CITY OF ALBUQUERQUE

July 12, 2023

RE: Allaso High Desert
LOMR Request Engineer's Stamp Date: 06/07/2023
Hydrology File: E22D023

TITLE:
**THE FOOTHILLS
PINO ARROYO STA 10+00 - END**
CONCEPTUAL PLAN AND PROFILE

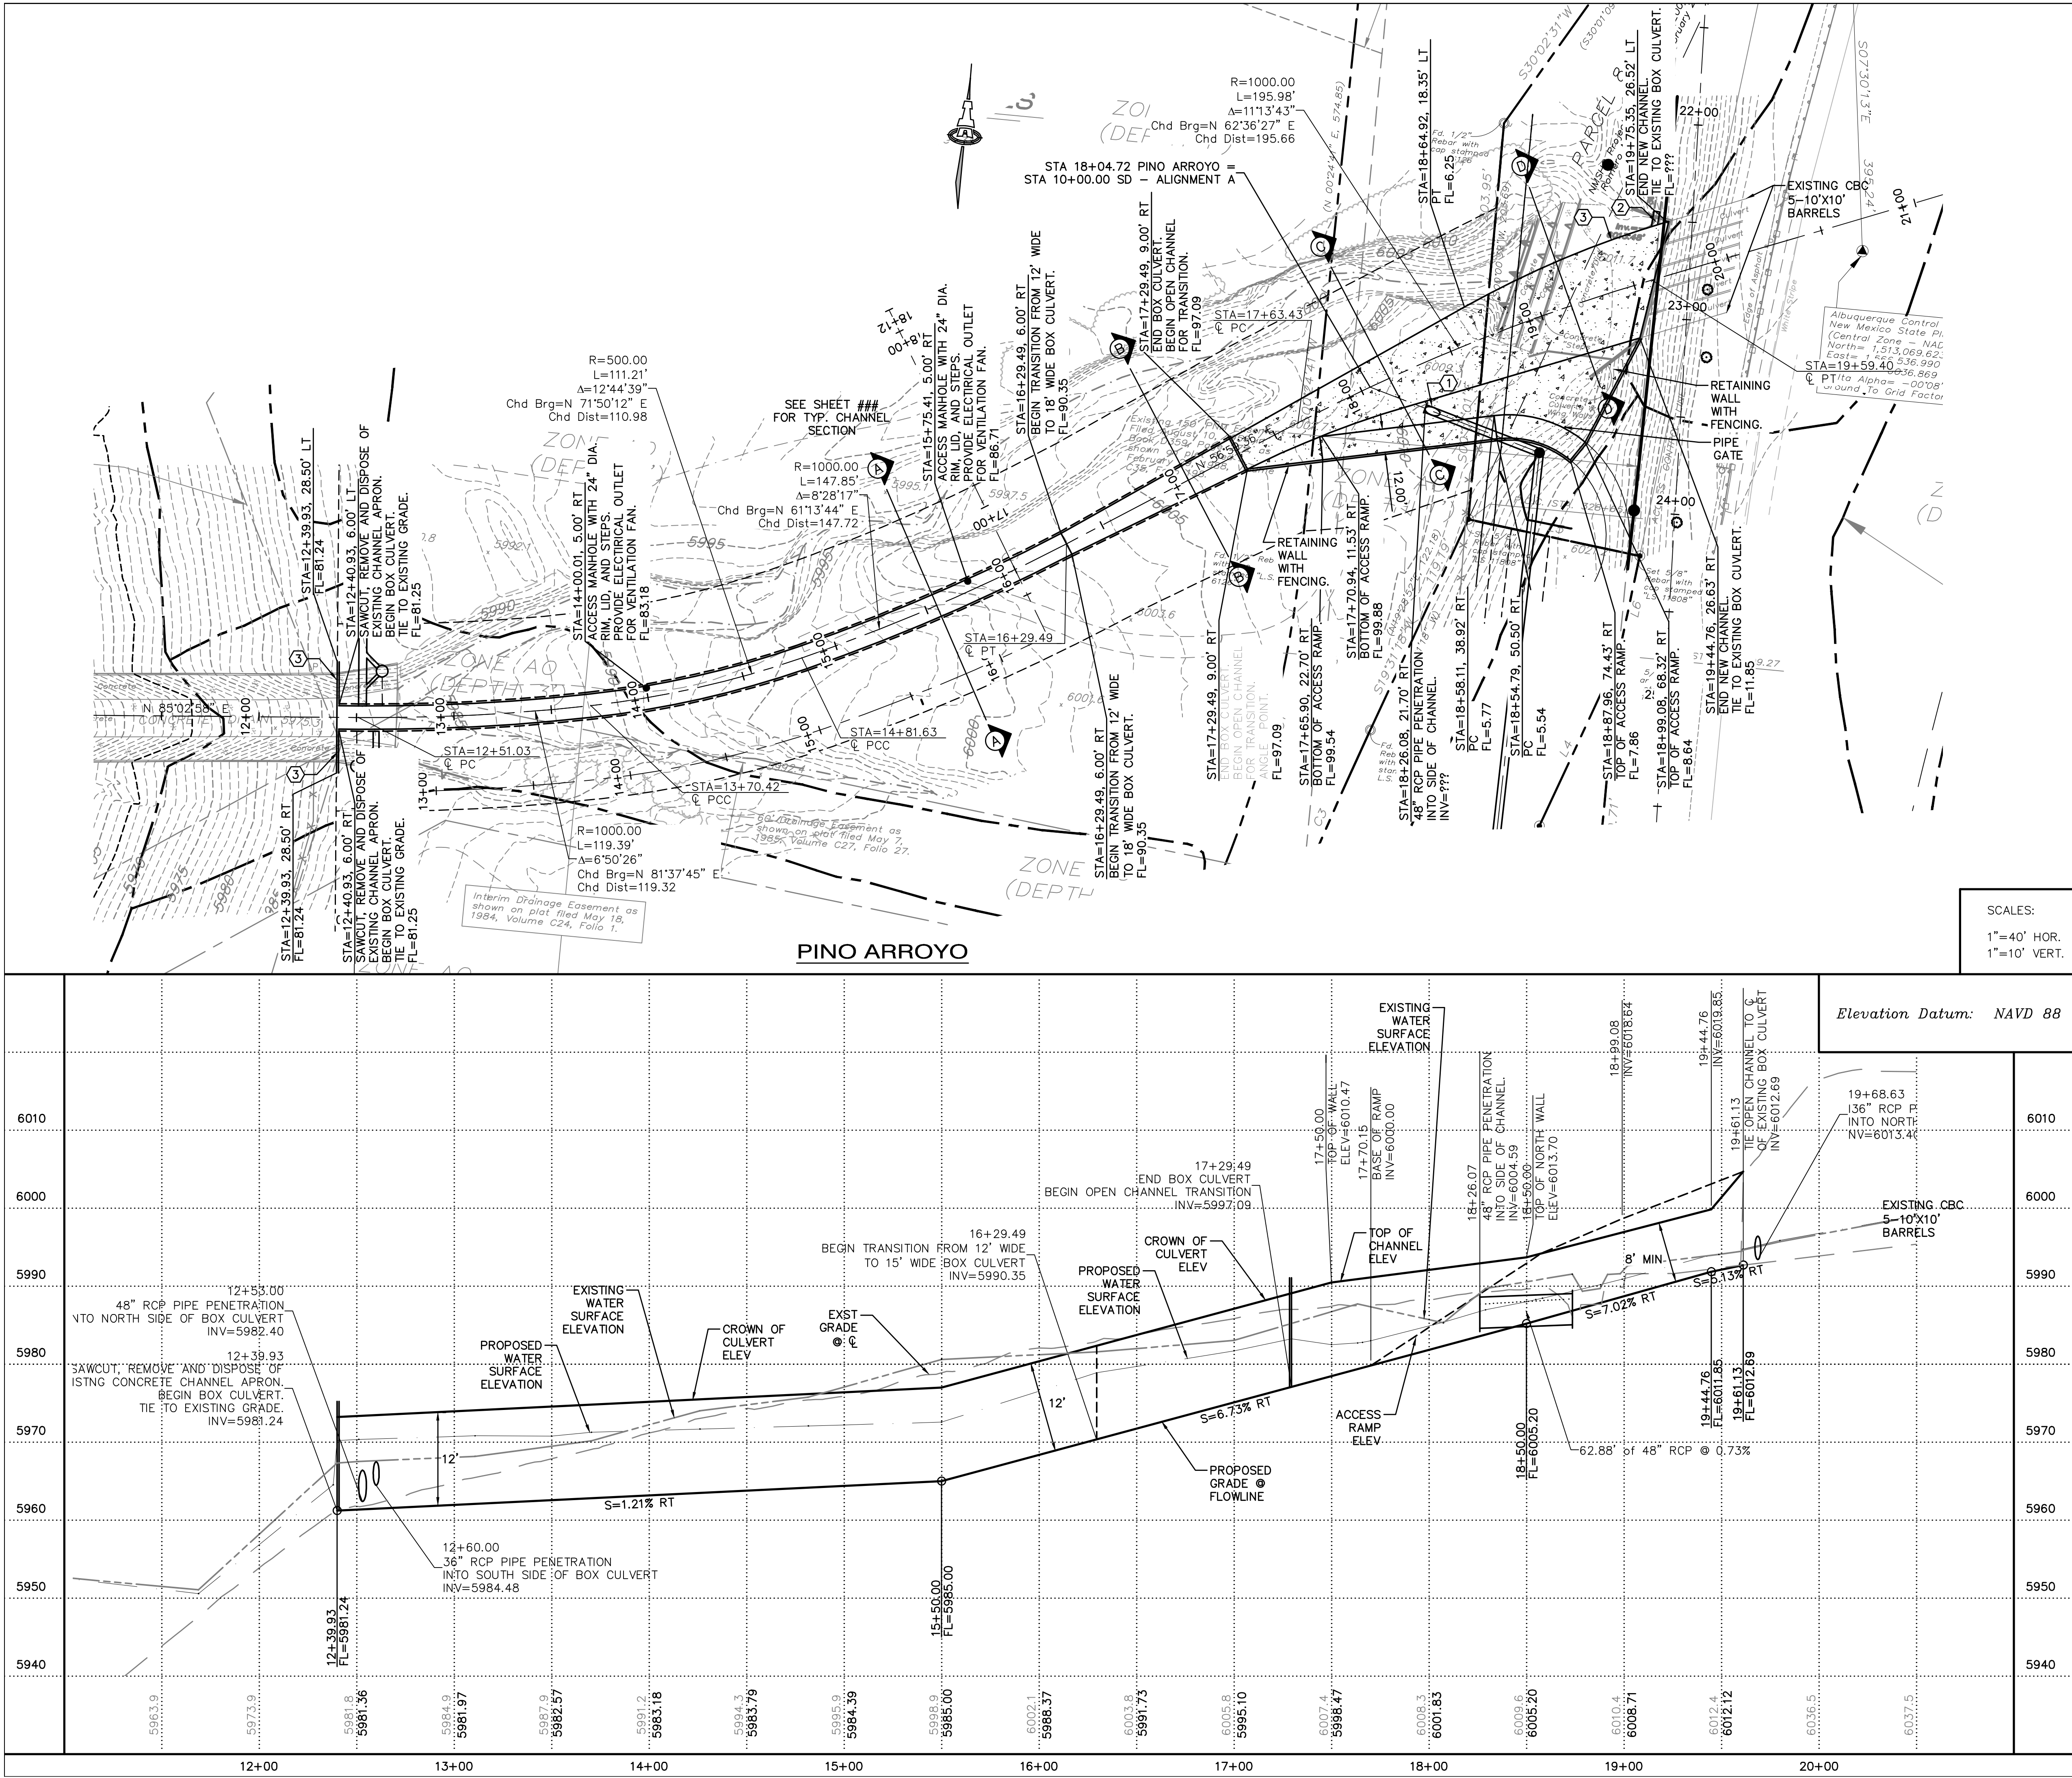
3. I have reviewed the HEC-RAS model and the as-built construction drawings for Pino Arroyo Channel. It appears that the model was built from downstream (the Pino Dam) to upstream (the natural arroyo on the east side of Tramway) and that the model flows that way. The model needs to flow from upstream to downstream. Please revised the model.

PINO ARROYO - EXISTING CONDITIONS Plan: Plan 15 4/28/2015
Geom: PINO ARROYO - EXST 2

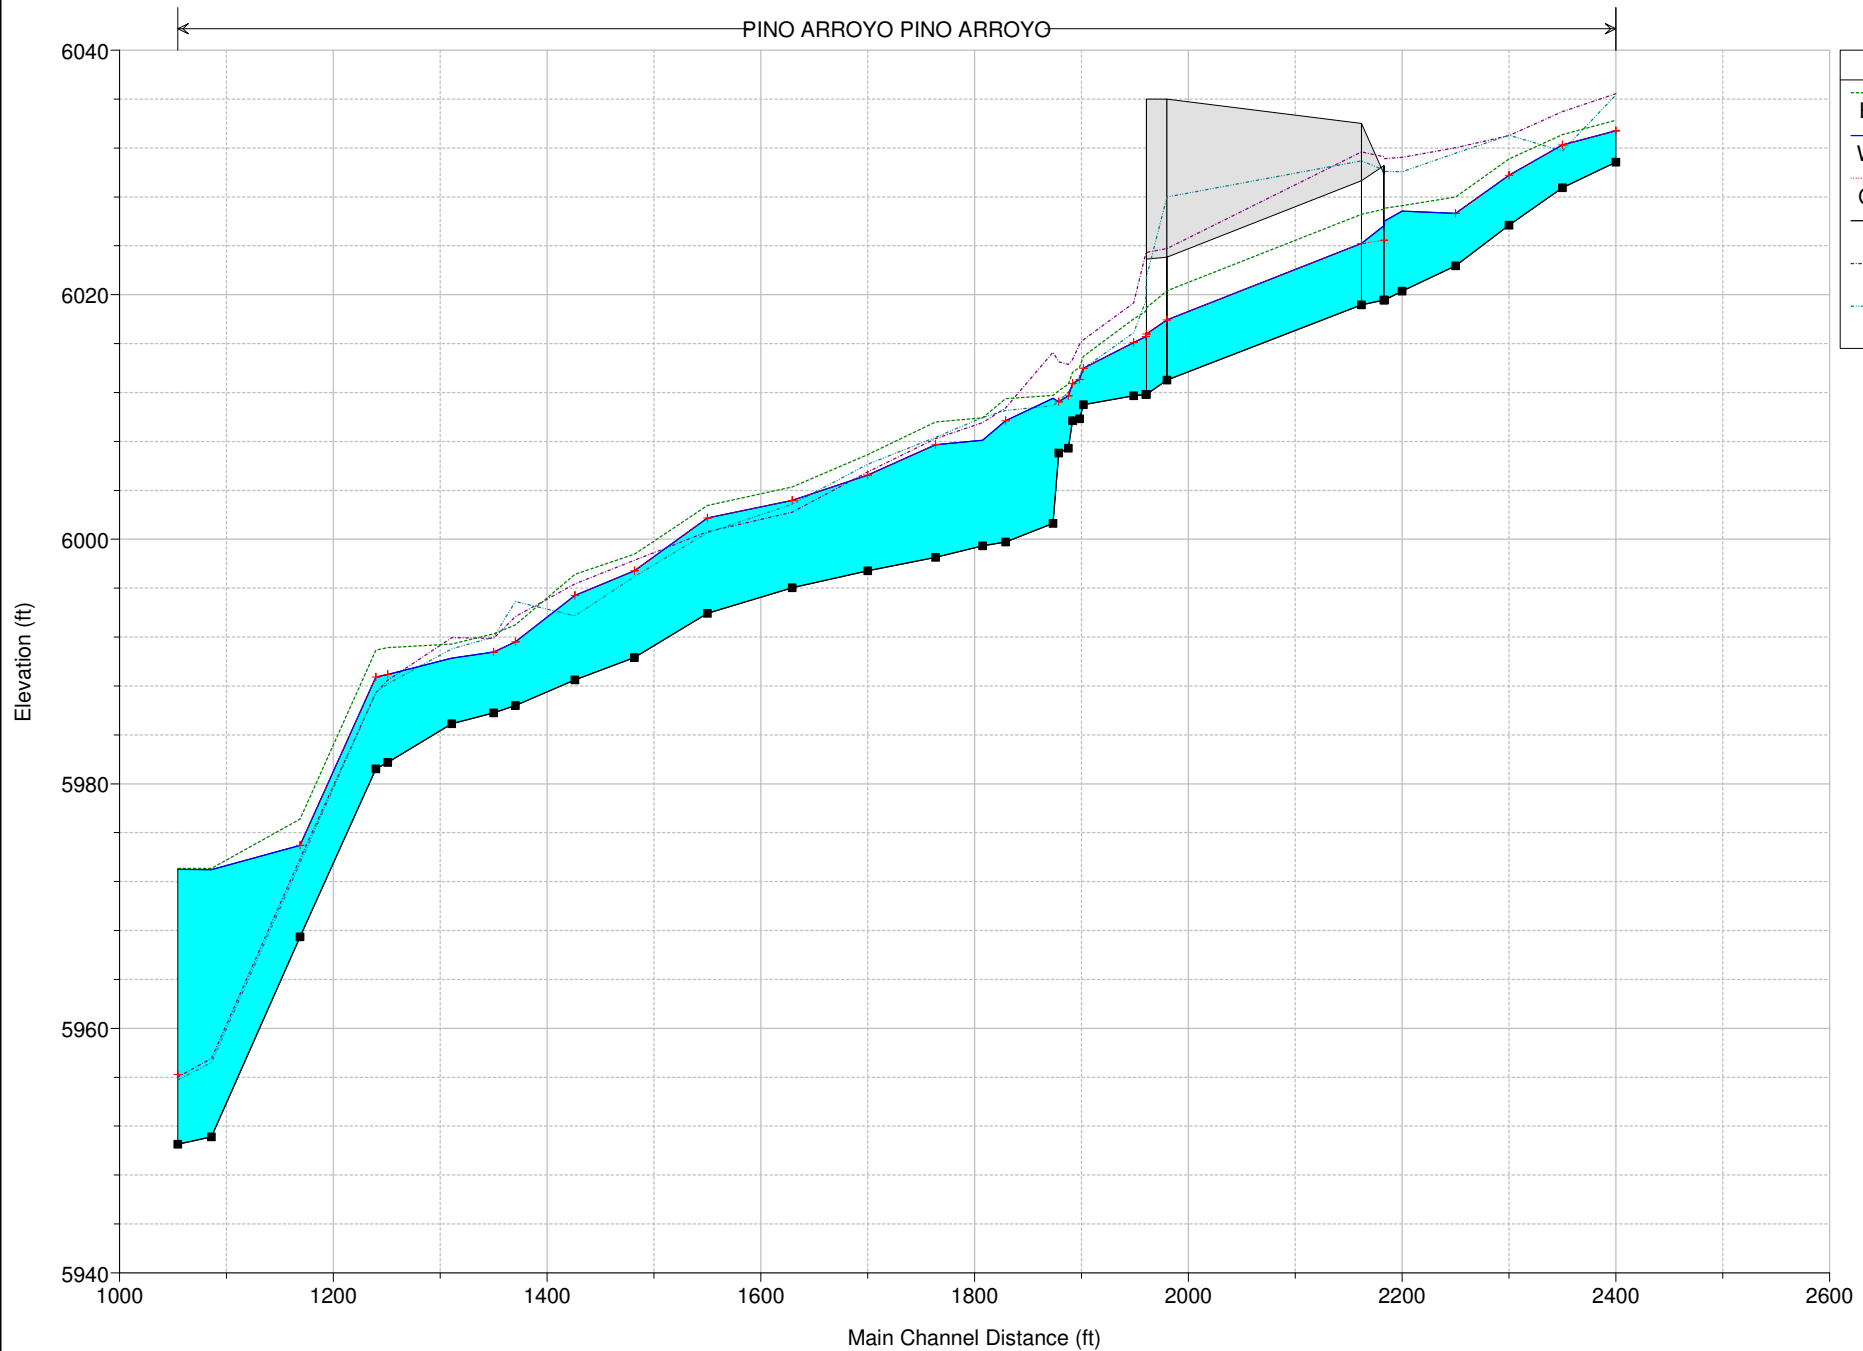
4. In the Report, the HEC-RAS Table only has 40 River Stations whereas the HEC-RAS model has more (about 400). These need to match. Are some of the River Stations in the model not needed? The sections here relate to Comment #2. The model could have several of the sections removed since they are all the same once it is in the box culvert. Please update and just keep all the important sections and remove the ones that do not add any value to the model. See below.
